M60/M62/M66 Simister Island Interchange

TR010064

7.24 WRITTEN SUBMISSIONS FOLLOWING NOVEMBER HEARINGS AND RESPONSES TO ACTION POINTS FROM CAH1 AND ISH2

December 2024

FIGURE 2.3

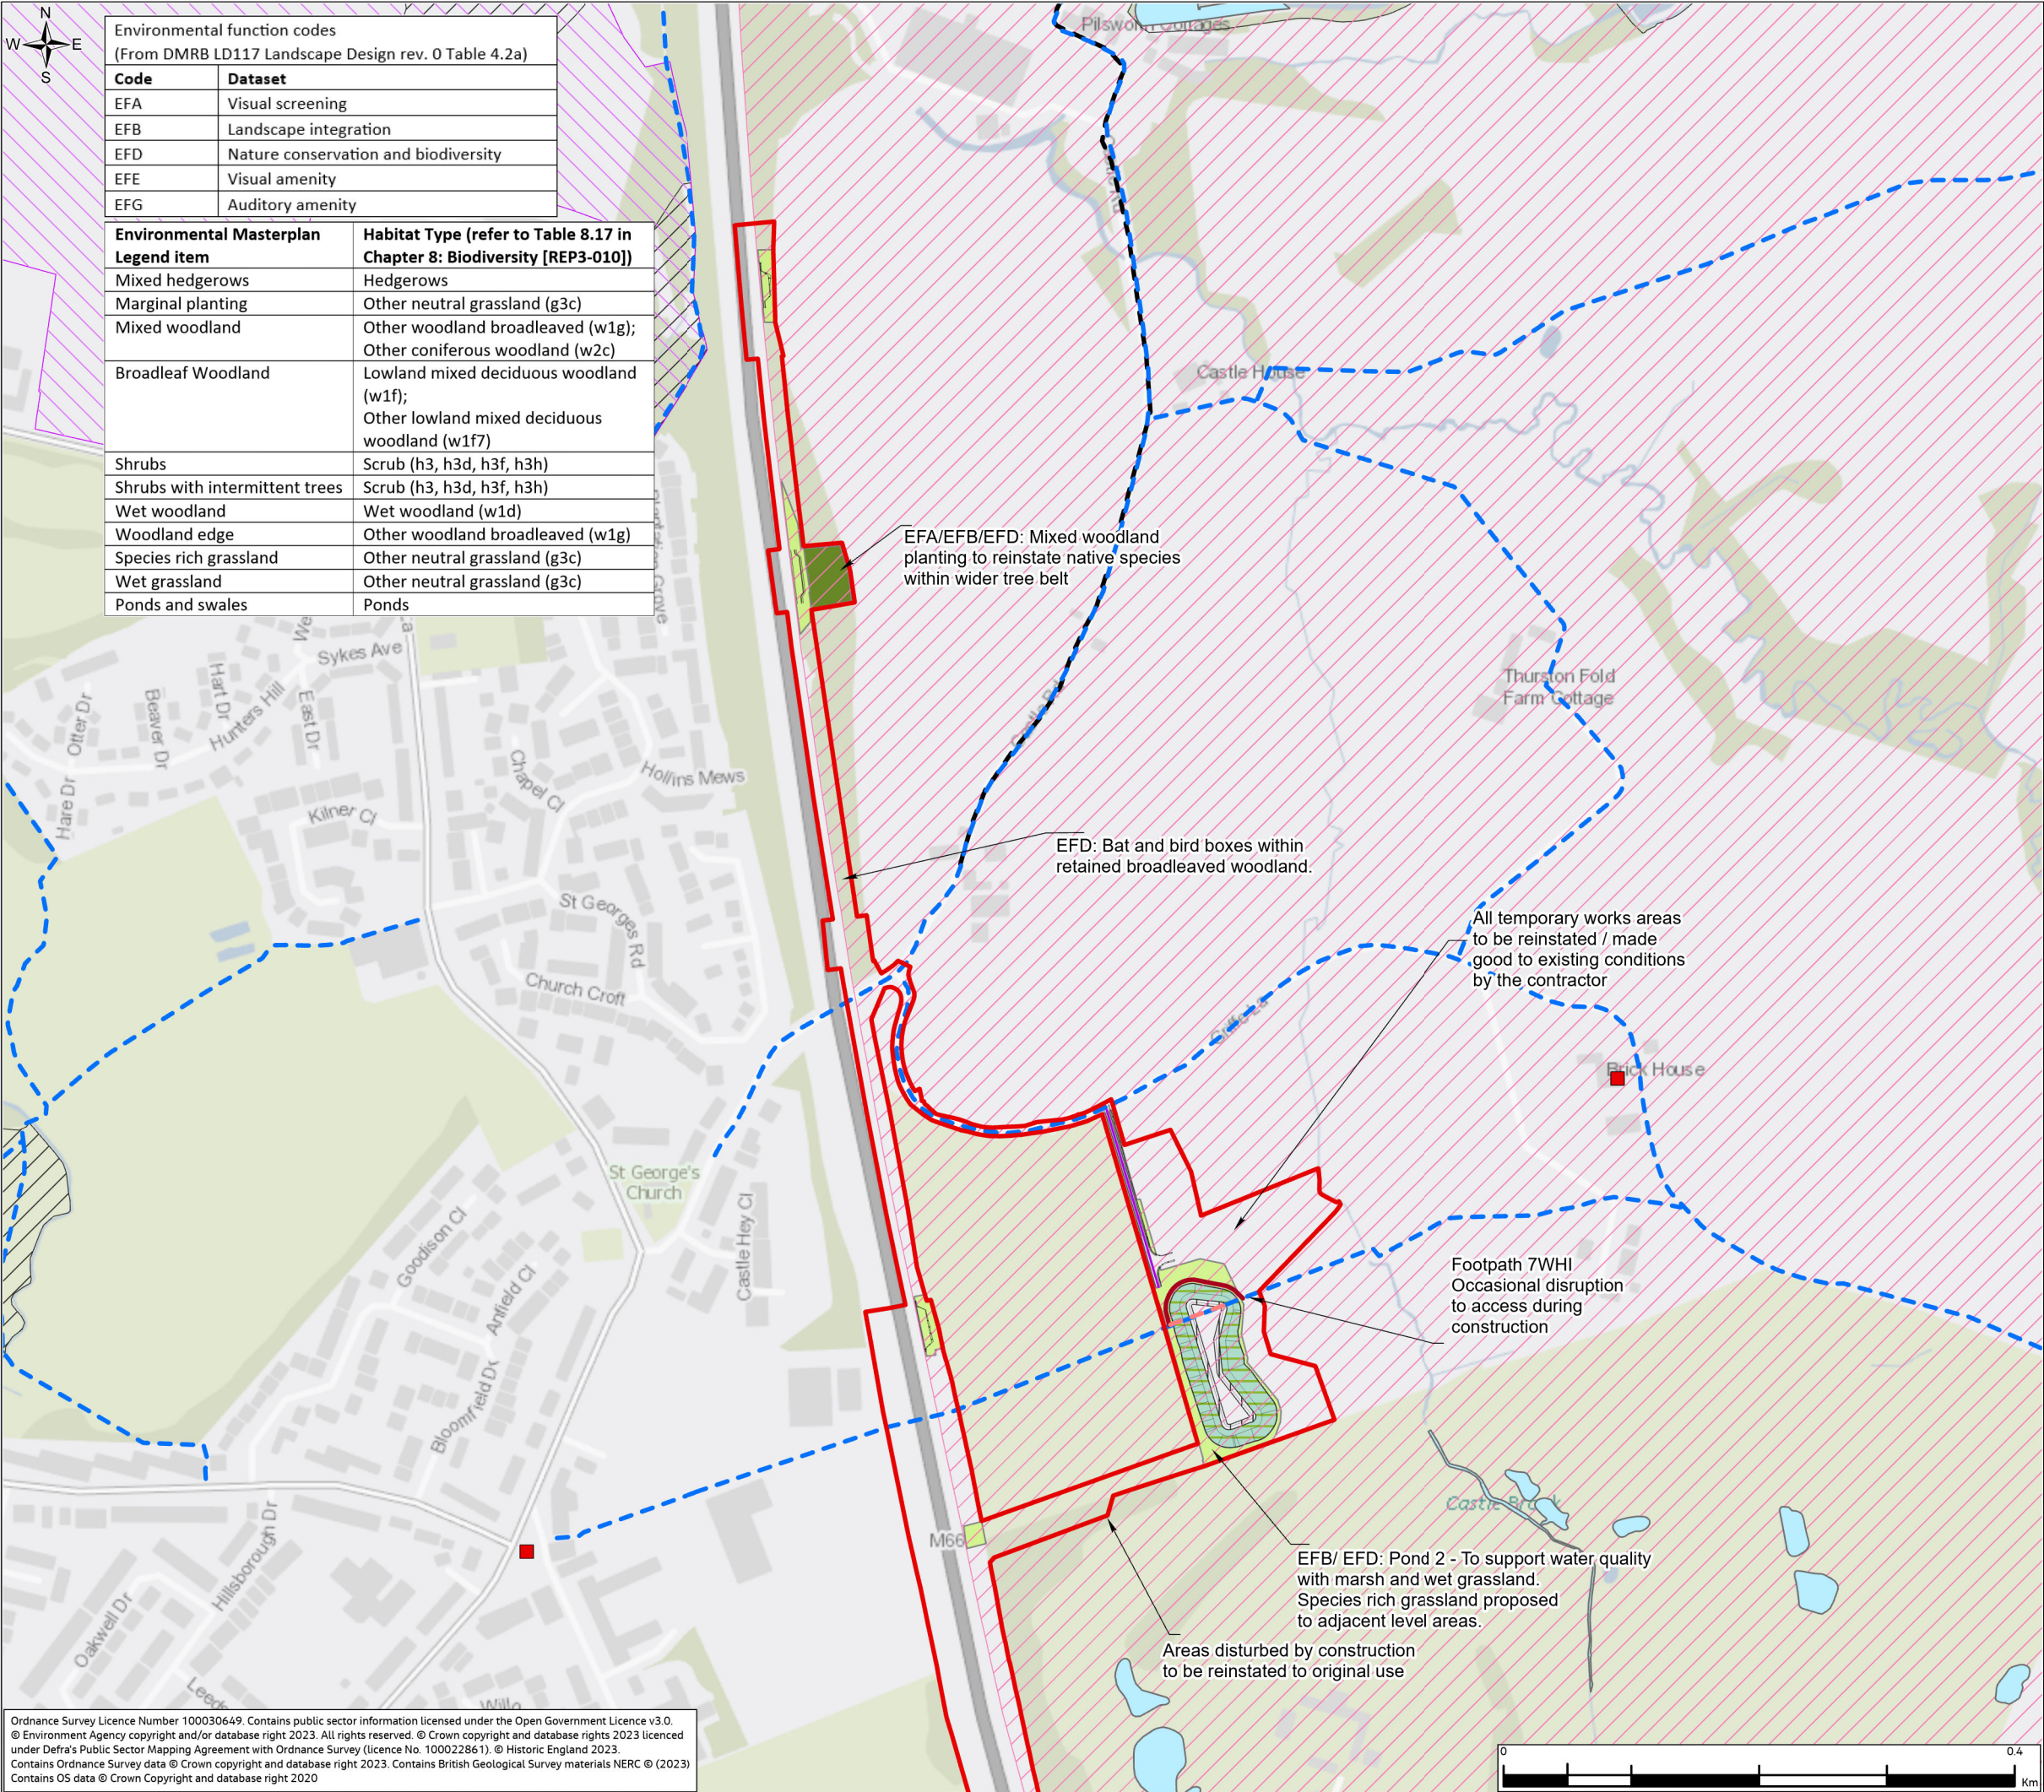
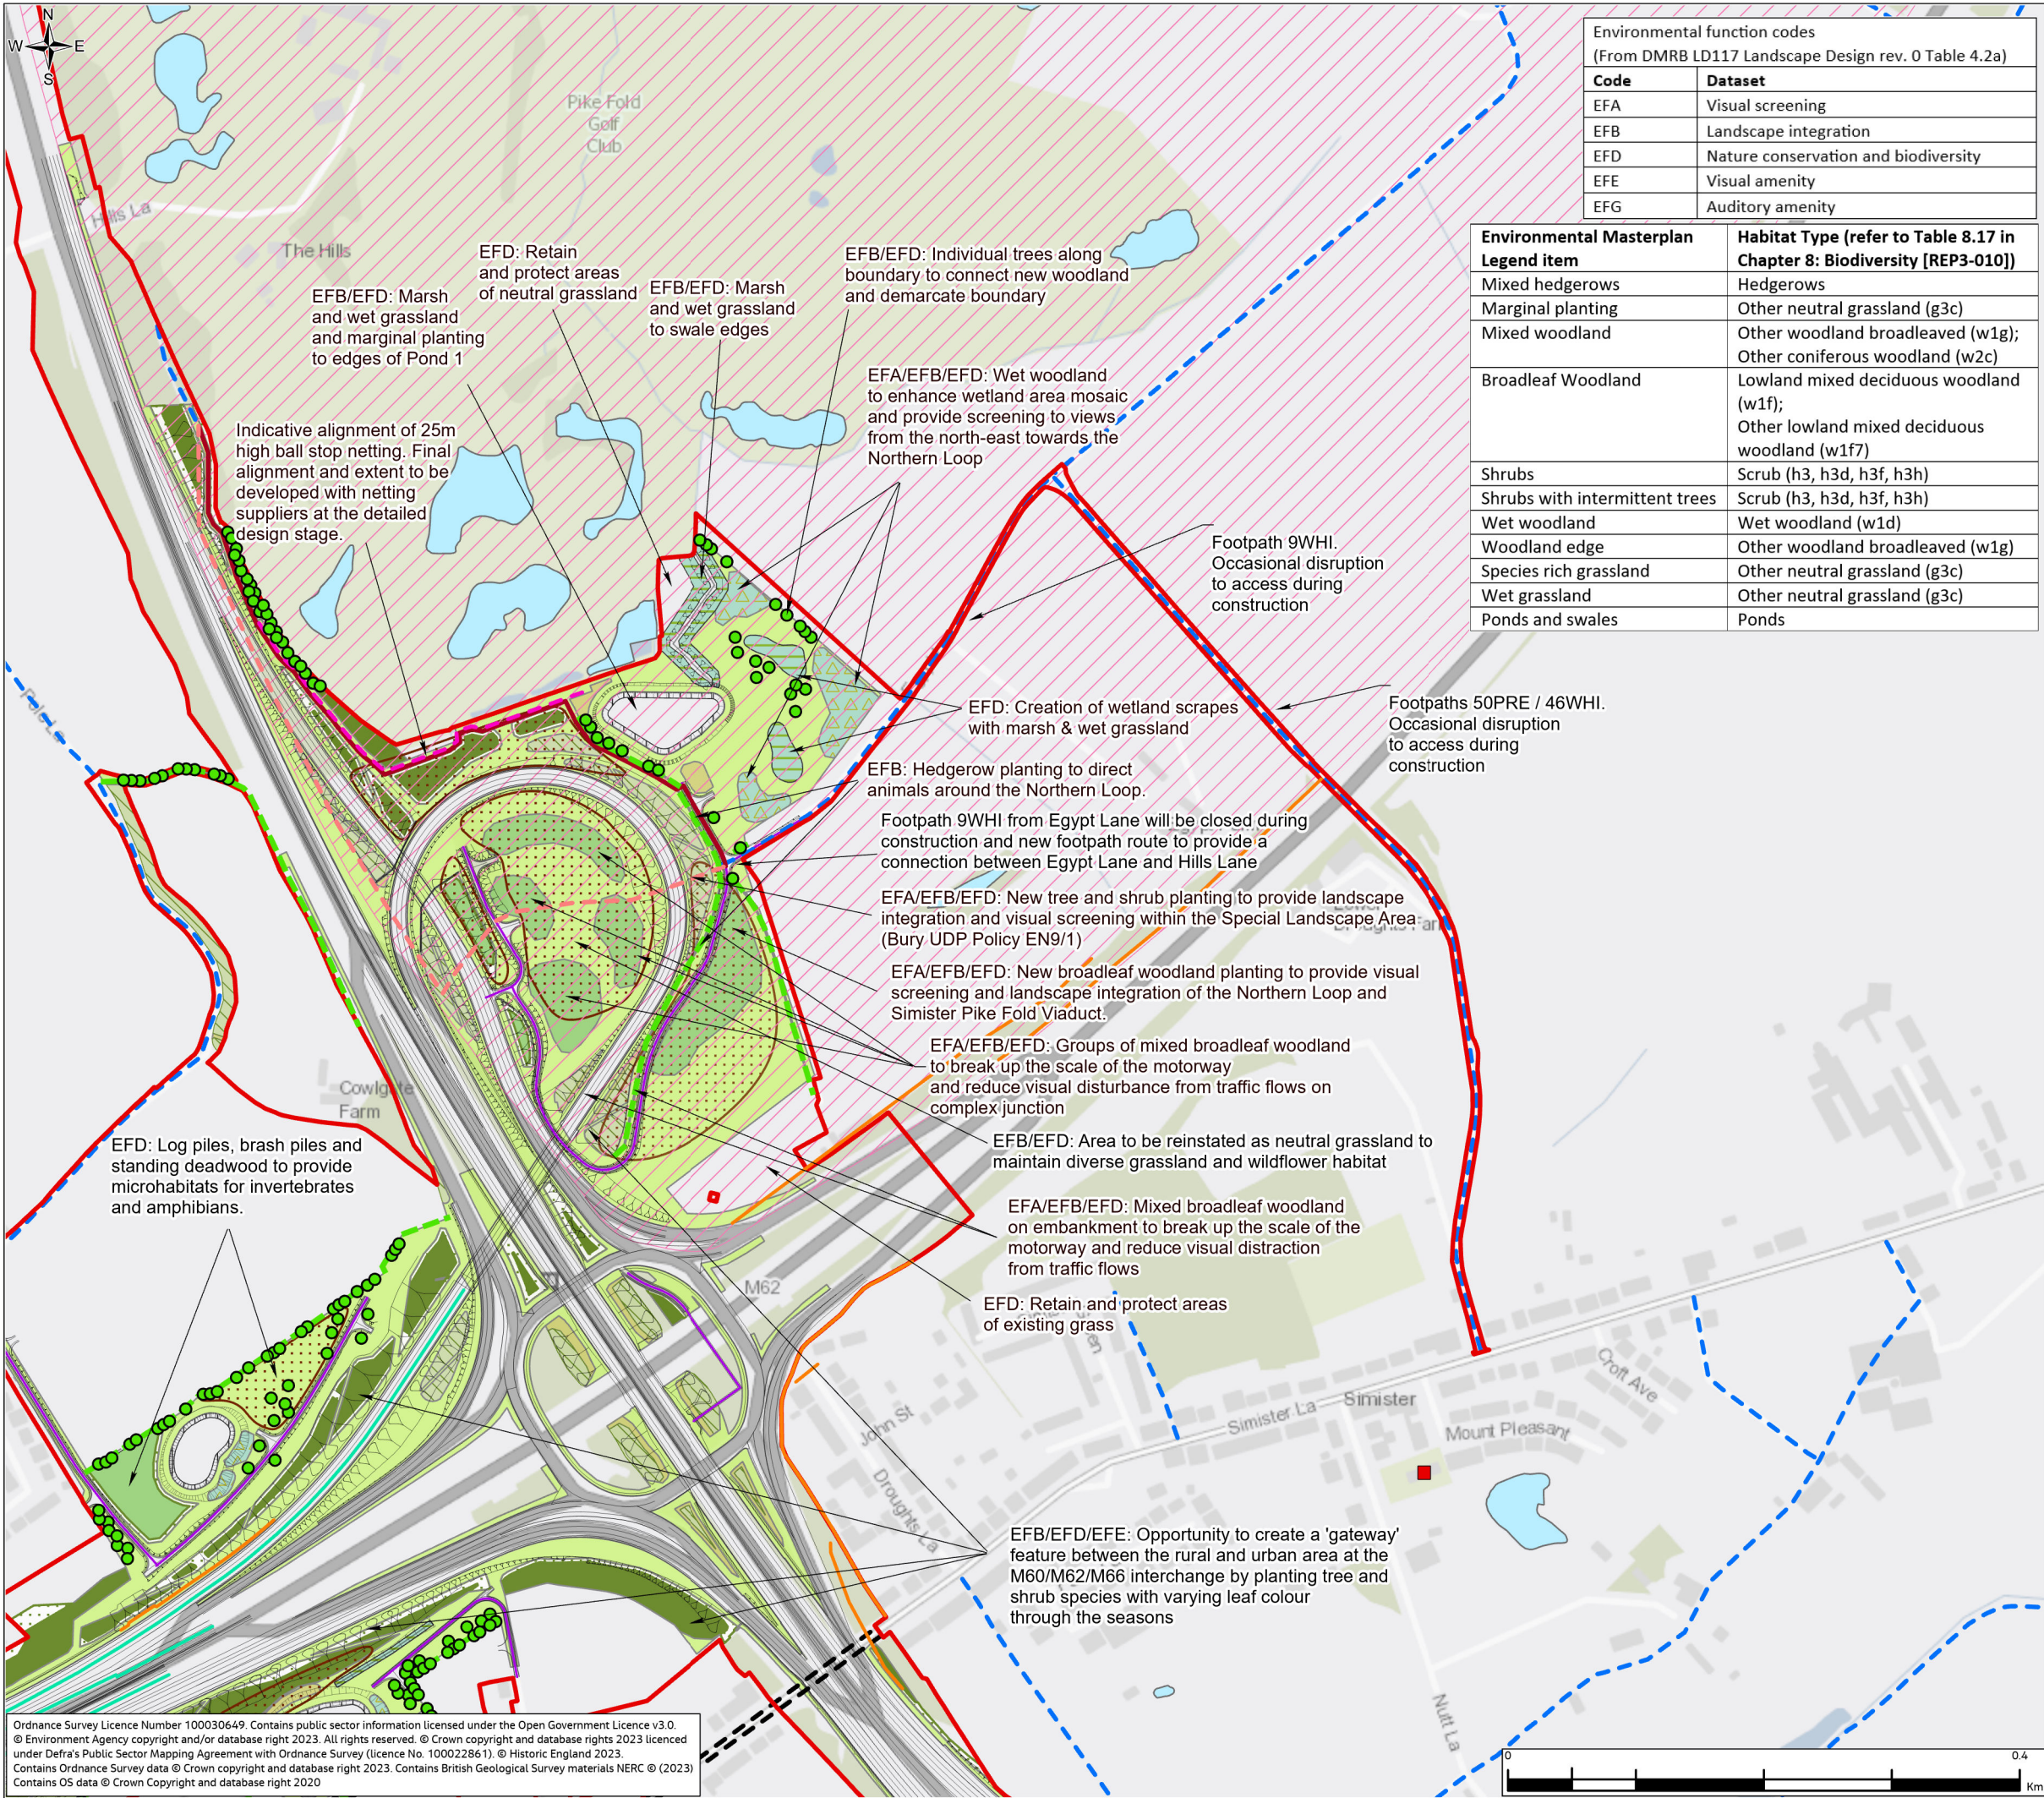
9	Explain why, when the design review panel "strongly encouraged the design team to introduce more trees across the Scheme", this was not included within the proposed design and was not considered feasible, notwithstanding your comments in Table 4-2 row 8 in the Scheme Design Report [APP-151].	The Applicant	D4	<p>The Design Council's comment needs to be understood in context. The Design Council review occurred at an early stage of the development of the preliminary design of the Scheme. Landscaping design ordinarily occurs towards the end of the design programme, once elements such as earthworks and the overall understanding of the Scheme design "footprint" are known. This is to avoid abortive design work and re-work on elements of the design that might end up being removed from the Scheme design prior to the final environmental impact assessment and DCO application.</p> <p>The Applicant has reviewed the statutory consultation materials used (as shown in Annex L of the Consultation Report [APP-033]), and the presentation to the Design Council review meeting, which showed screenshots of the draft Environmental Masterplan provided in the Preliminary Environmental Impact Report (provided in Annex L of the Consultation Report [APP-033] and the Scheme visualisation used during the Design Council presentation and Statutory Consultation.</p> <p>At that time, the Scheme visualisation did not show or illustrate any landscape planting for the reasons cited above; Scheme visualisations require a 3D model of tree planting and this had not been developed. Therefore, the Design Council comment related to tree planting, was made at a point when there was an absence of landscape planting from the Scheme visualisations.</p> <p>In response to Statutory Consultation and after the point of engagement with the Design Council, several areas were subsequently removed from the Scheme. For example, the area north of the M60, west of Junction 17 where Pond 6 was located, the area west of pond 5, south of J18 and the area to the far north and east of the northern loop were removed. Details of these changes can be found in Table 5-14 of the Consultation Report [APP-021] and by comparing the Land Plans [REP3-004] with Map Book 2 – Land Use Plans used at Statutory Consultation which are provided in Annex L.9 of the Consultation Report [APP-033]. The overall reduction in area meant that tree planting opportunities were reduced in comparison to the point when the Design Council provided its observations.</p> <p>The Applicant considers that the volume of replacement tree planting is proportionate to the loss and is balanced against the environmental mitigation requirements of the Scheme. The quantum of trees shown within the landscape proposals also reflects the physical and geo-physical constraints of the Scheme area, specifically along the M60 corridor between J17 and J18 of the M60 which is particularly constrained. The presence of buried services such as statutory undertaker apparatus and drainage infrastructure also limit tree planting along their respective corridors due to the risk of root ingress and potential restrictions for future maintenance access.</p> <p>As outlined in Table 4-1 of the Scheme Design Report [APP-151], the landscape design and planting design fits into the context of the Scheme. Specifically, the Scheme landscaping has taken the Bury Unitary Development Plan (UDP) land use designations into account including Bury UDP Policy Env 9/1 Special Landscape Area and the Green Belt. For example, carefully designed groups of trees and shrubs to help integrate into the surrounding vegetation pattern. Particular attention has been given to avoid, reduce or remediate (offset) potential effects on the Special Landscape Area. Mitigation</p>

16	Review what is included within the proposed Scheme in respect of safety measures for footpath 9WHI and whether any planting/screening from the motorway for mitigation is included, or could be included, which could be considered an enhancement	The Applicant	D4	<p>The Applicant confirms that, as shown on the General Arrangement Plans [APP-005] between chainage 2210 (where the diverted Public Right of Way (PRoW) (9WHI)) connects to the existing alignment and chainage 2020, the PRoW is at the top of a cut slope (i.e. above the new M66 southbound diverge), following this, the new M66 southbound diverge transitions to embankment. As such, during the detailed design, a detailed assessment of risk will be undertaken that considers the proximity of the PRoW to the M66 Southbound diverge link and the height of embankment to determine whether a safety barrier will need to be installed and, if so, over what longitudinal distance.</p> <p>Where a safety barrier is required on the approach to the Pike Fold Bridge, it will connect to the parapet of the new Pike Fold Bridge and this combination of safety barrier and bridge parapet will ensure that vehicles cannot deflect down and onto the PRoW. A Stage 2 Road Safety Audit will be undertaken at the detailed design.</p>

Action	Description	Action by	When	Applicant Response & Summary of Action taken
				Figure 2.3: Environmental Masterplan, of the Environmental Statement Figures [APP-057] shows the proposed mitigation planting, secured through Requirement 5 of the draft DCO [REP3-006]. In this area mitigation planting, consisting of native woodland, native shrub and intermittent tree belts, is proposed on the embankments of the Northern Loop and M66 southbound diverge link to both integrate the earthworks and provide screening of traffic in wider views from the east, including the PRoW. Hedgerow planting, along the diverted section of footpath 9WHI is provided adjacent to balancing pond 1 to link the field patterns and also provide immediate screening for closer range views once established. The majority of planting areas are of a suitable size (over 5m width) that once established should provide adequate screening of views from a user of footpath 9WHI to the M66 and most of the northern loop traffic. North of where the diverted section of footpath 9WHI connects to the existing alignment, views will be as they are presently.
